# CITY OF ALBUQUERQUE

**Re: Dunkin Donuts**  
**2301 Juan Tabo Blvd NE**  
Architect's Stamp dated 01-08-16 (H21D051)  
Certification dated 08-16-16

## DRAINAGE AND TRANSPORTATION INFORMATION SHEET (REV 09/2015)

Project Title: Dunkin Donuts Building Permit #: \_\_\_\_\_ City Drainage #: H21D051  
 DRB#: \_\_\_\_\_ EPC#: \_\_\_\_\_ Work Order#: \_\_\_\_\_  
 Legal Description: Snow Heights Addition, Parcel 1-A, Block 88-B  
 City Address: 2301 Juan Tabo Blvd NE

SITE PLAN, SITE DATA
AND TCL

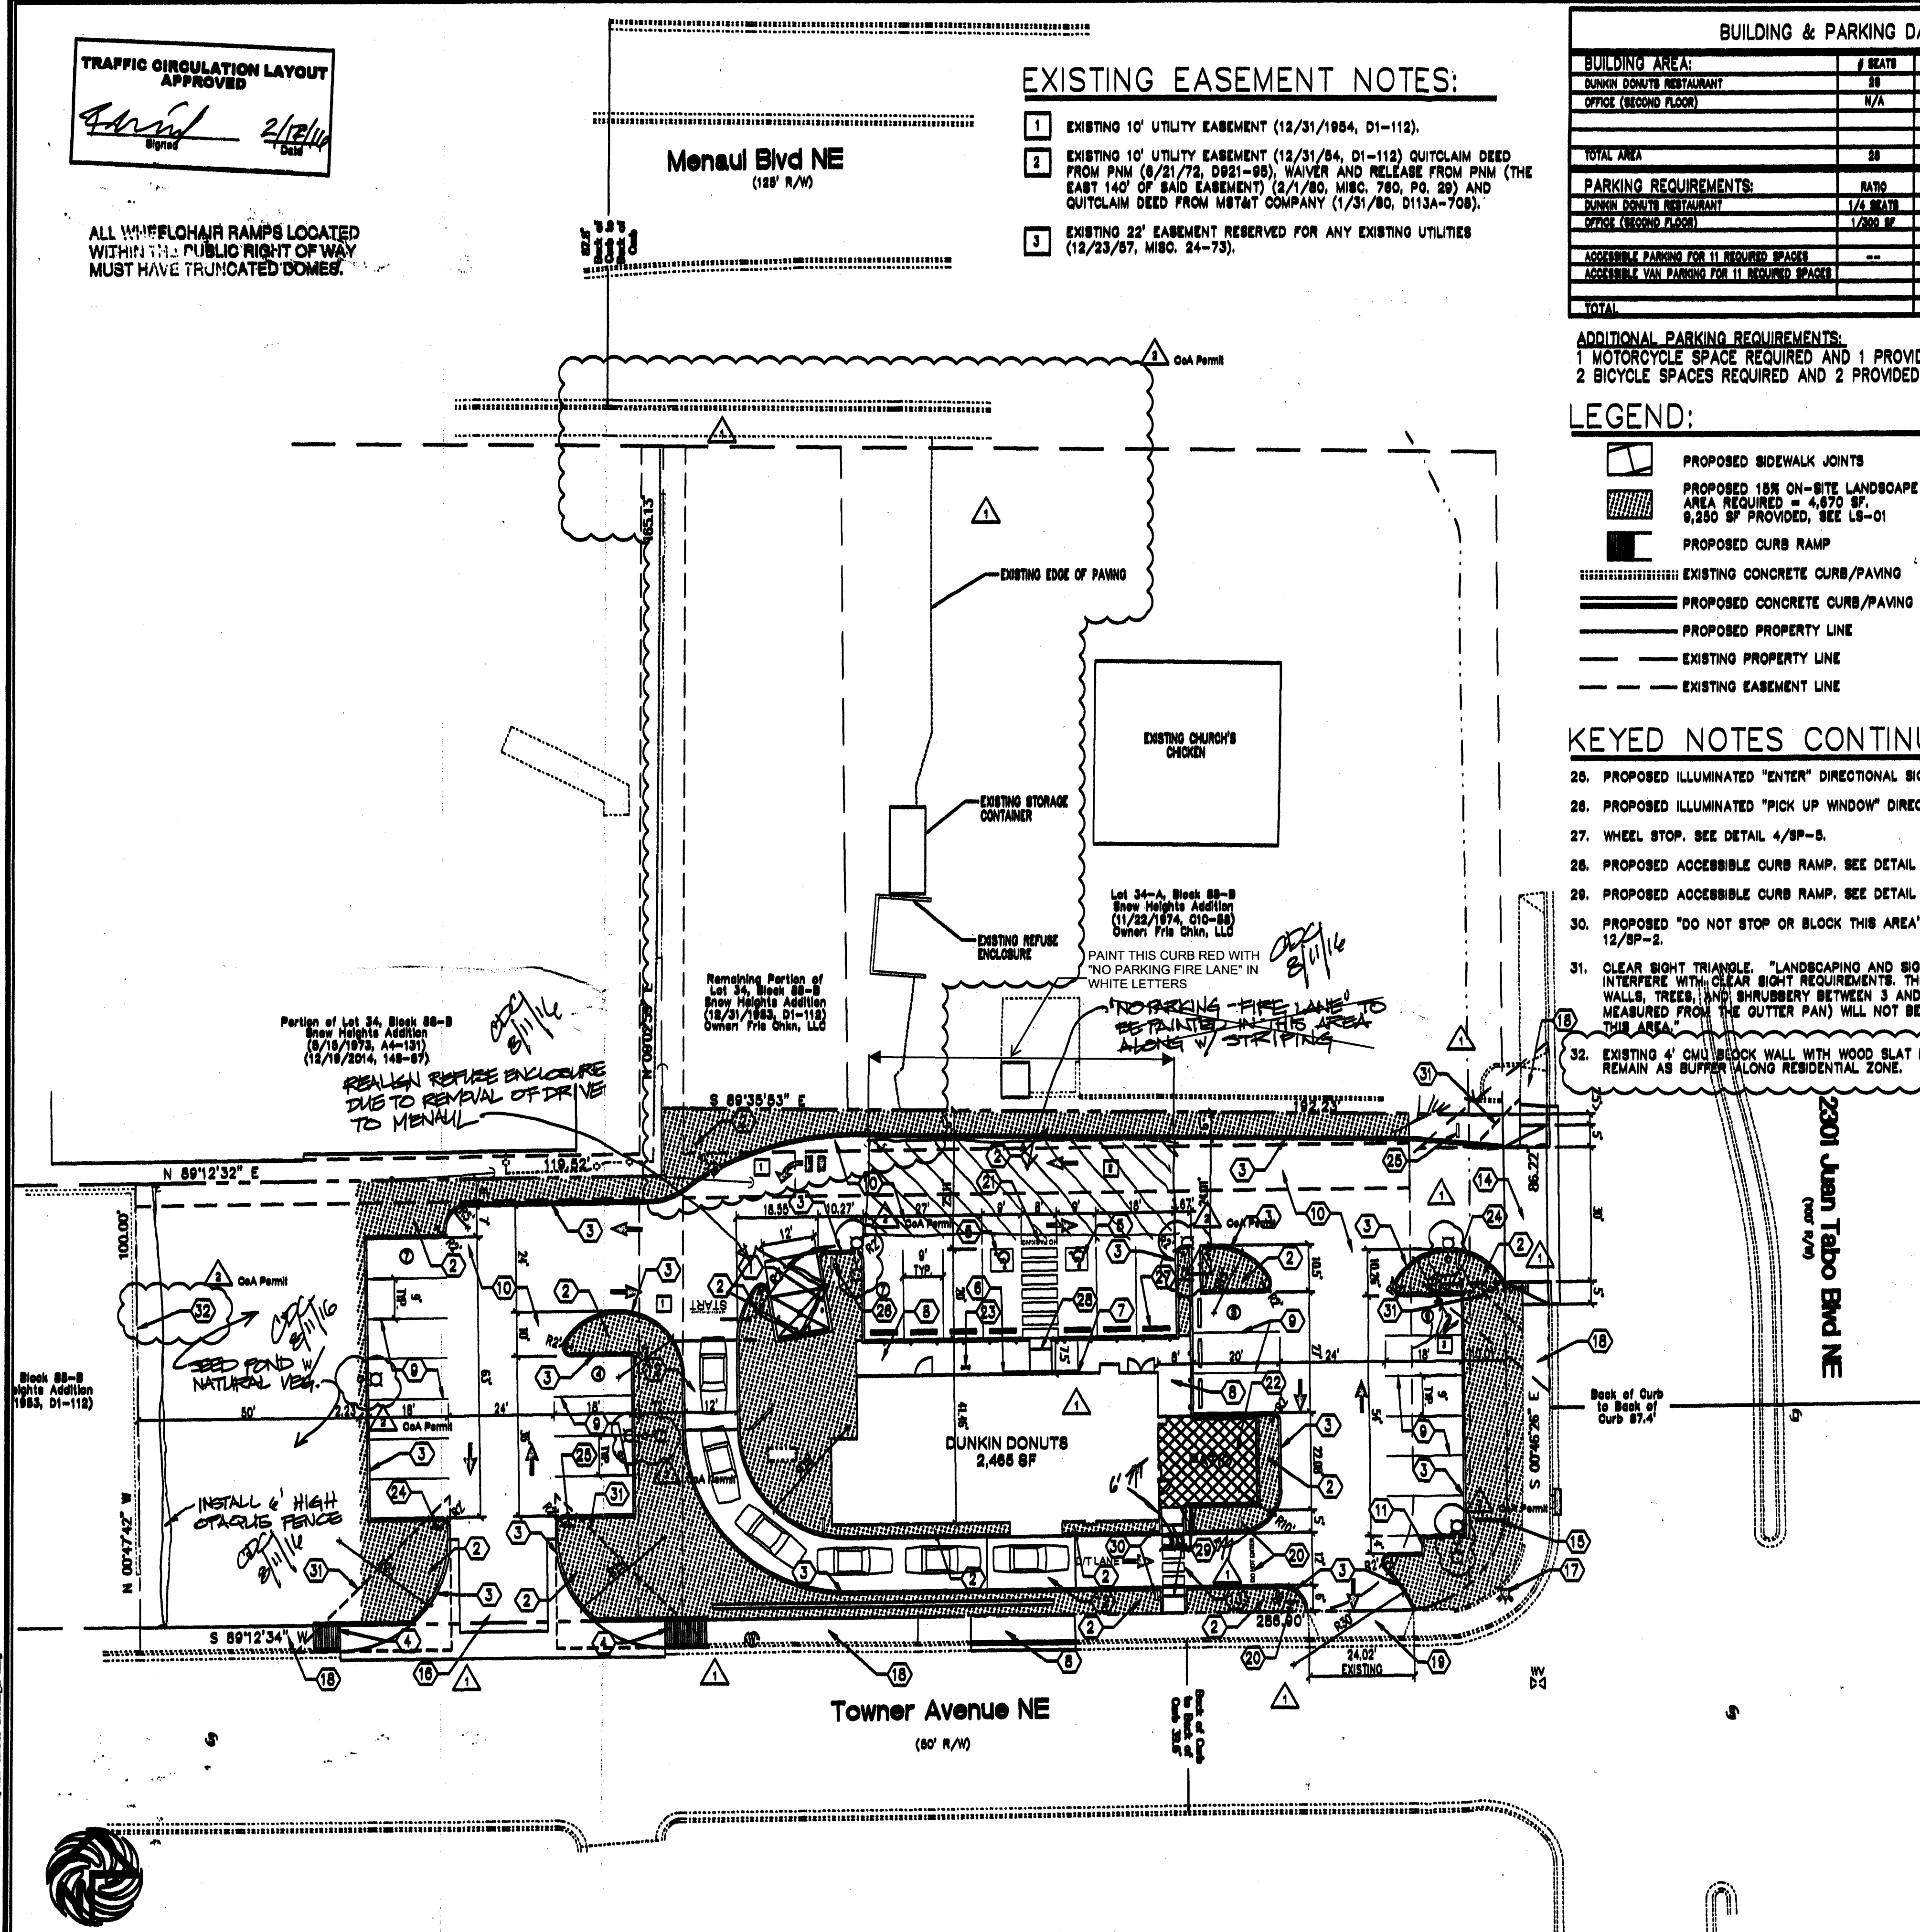
- The header curb on the north end of the property, across from the handicapped parking will need to be painted red with white lettering "No Parking Fire Lane".

1. Paint header curb, on north side of the property and across from the accessible parking, red with "NO PARKING FIRE LANE" painted in white letters.

C1.1 - Grading Plan

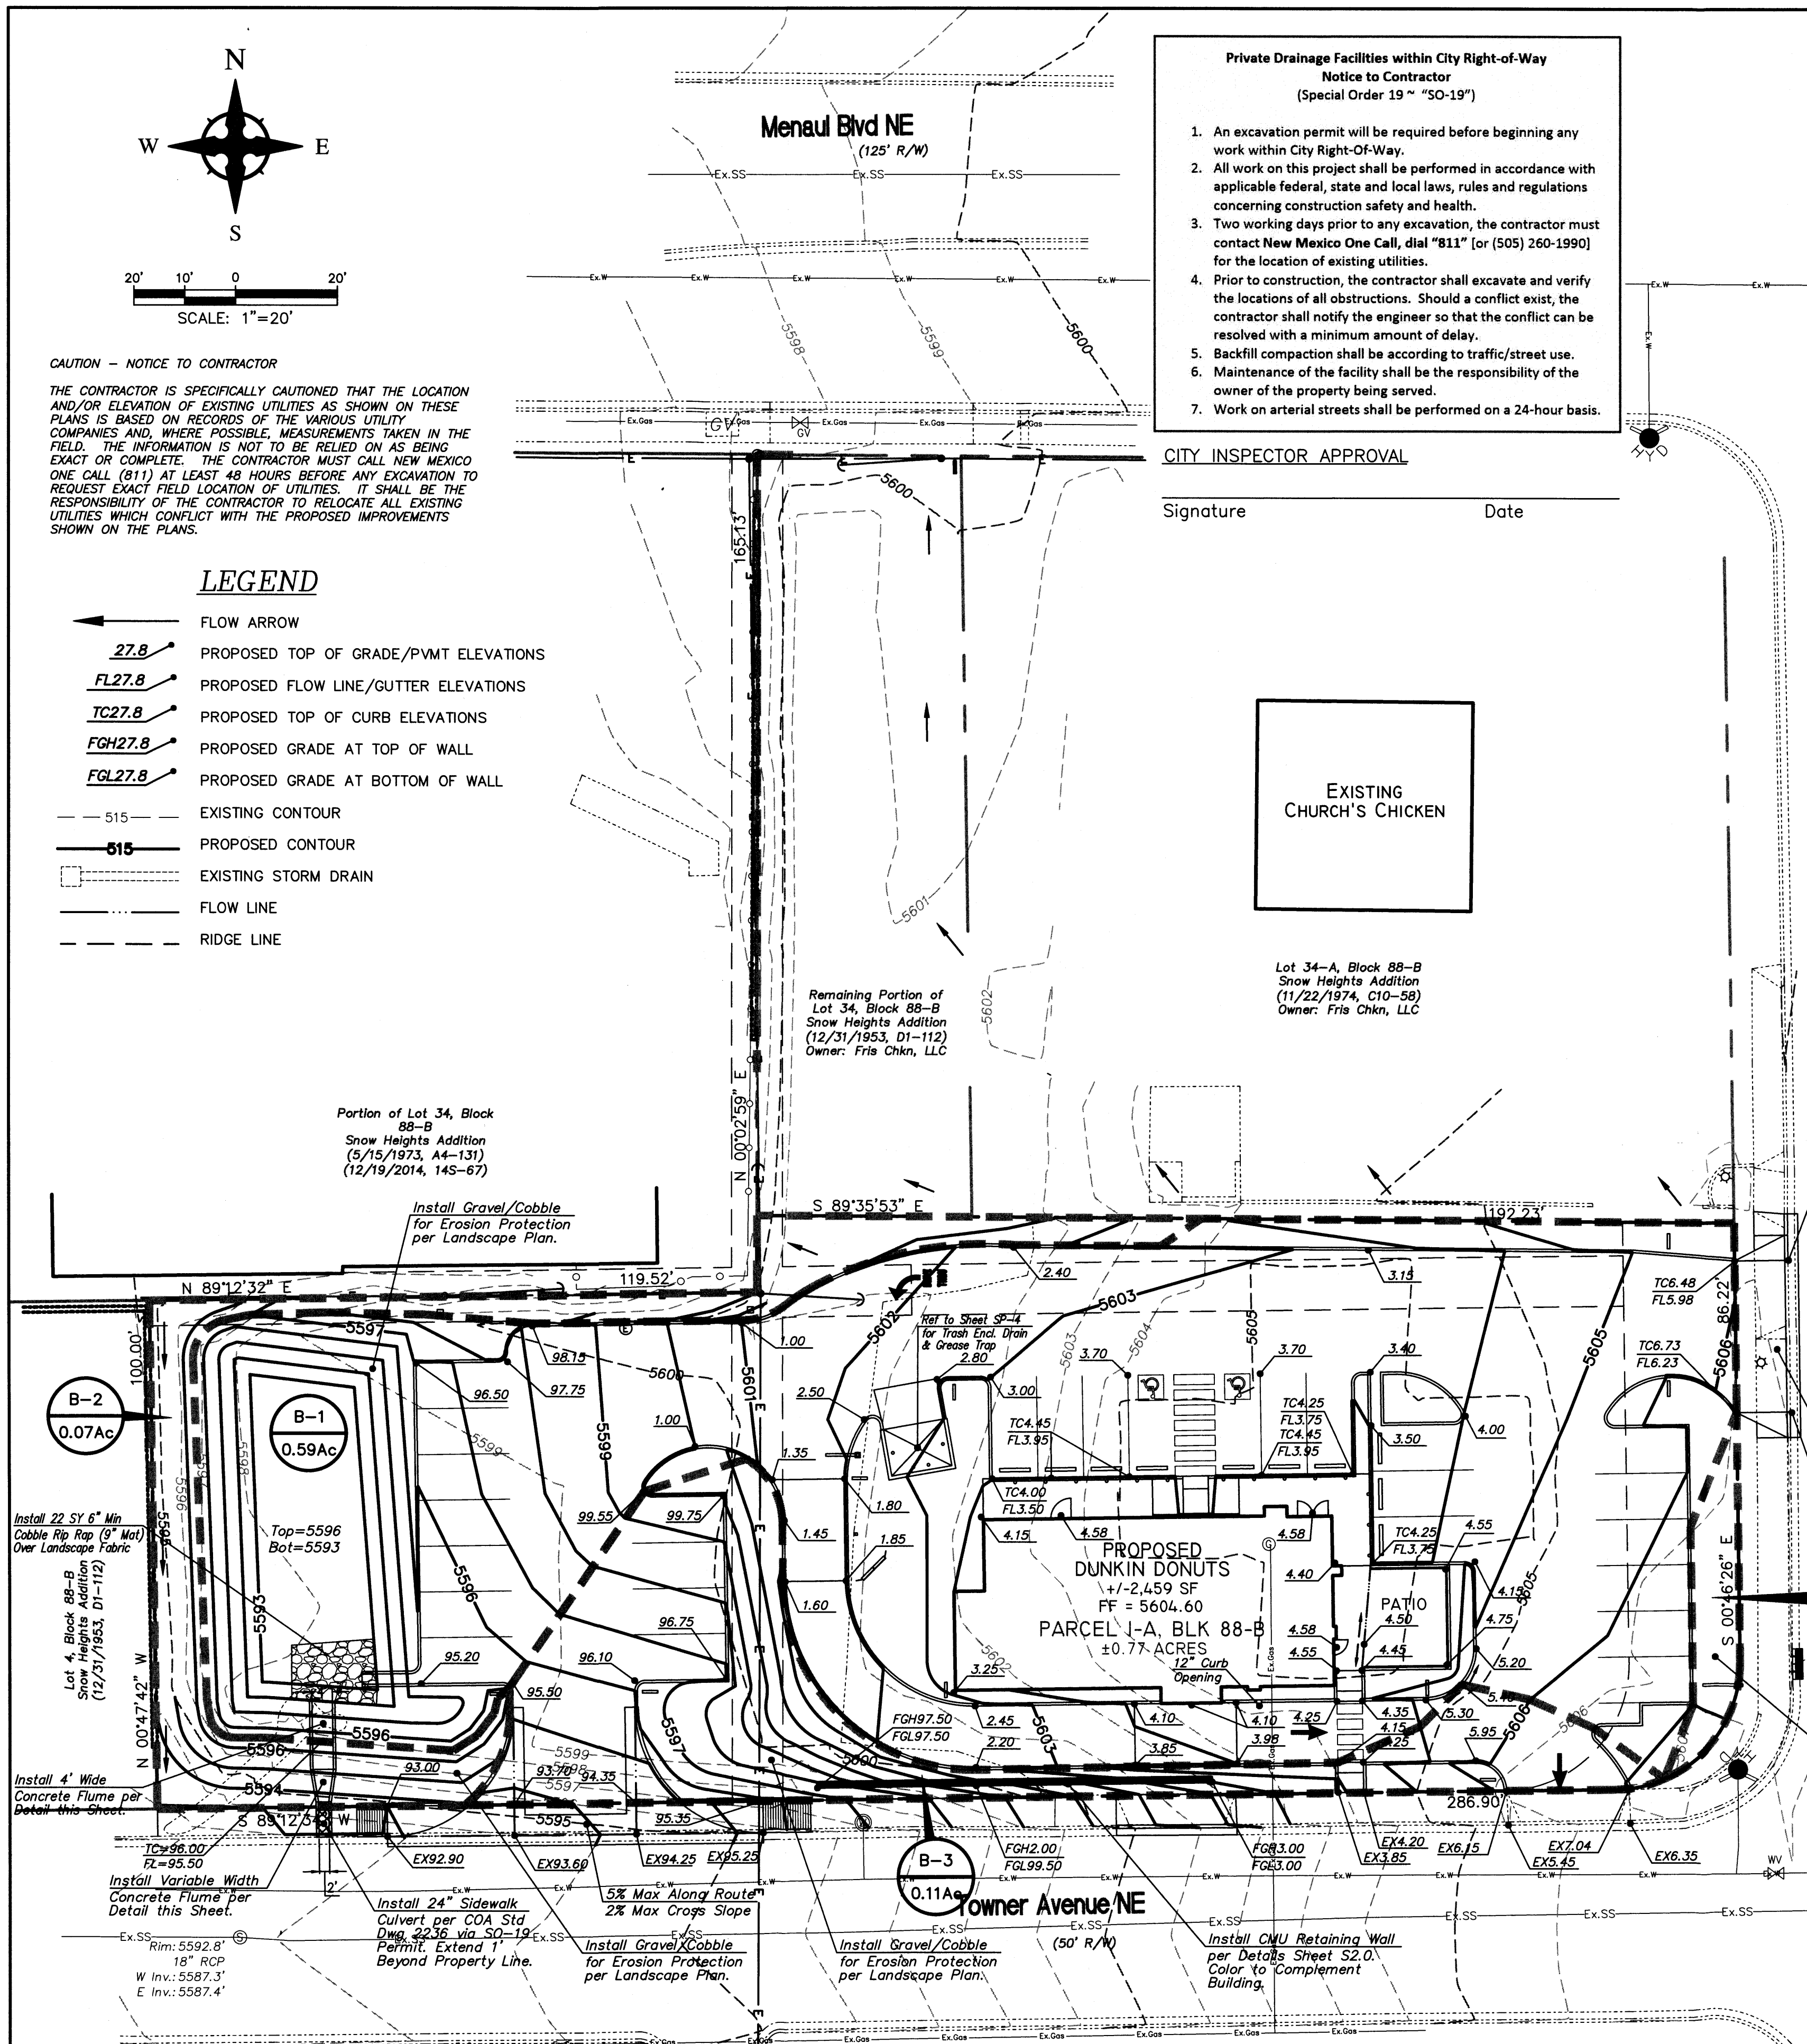
1. Trash enclosure needs drain attached to the SAS with a grease trap.
2. Build notes are needed for the pond and the sloped area by the driveway for erosion protection.
3. Bottom of pond needs erosion protection at the end of the entry channel.
4. Flow line/gutter elevation needed for the entry on Juan Tabo.
5. Extend the sidewalk culvert 1' passed the property line.

1. The trash enclosure drain and grease trap are both shown on the architectural plans. We have added a keyed note to the plans referencing the sheet.
2. We have added several notes referencing the landscape plan for gravel/cobble treatments.
3. We have added rip rap as required where the concrete flume discharges into the pond.
4. Flow line/gutter elevations have been added to the new curb cut along Juan Tabo.
5. The sidewalk culvert has been extended 1' beyond the property line and labeled accordingly.
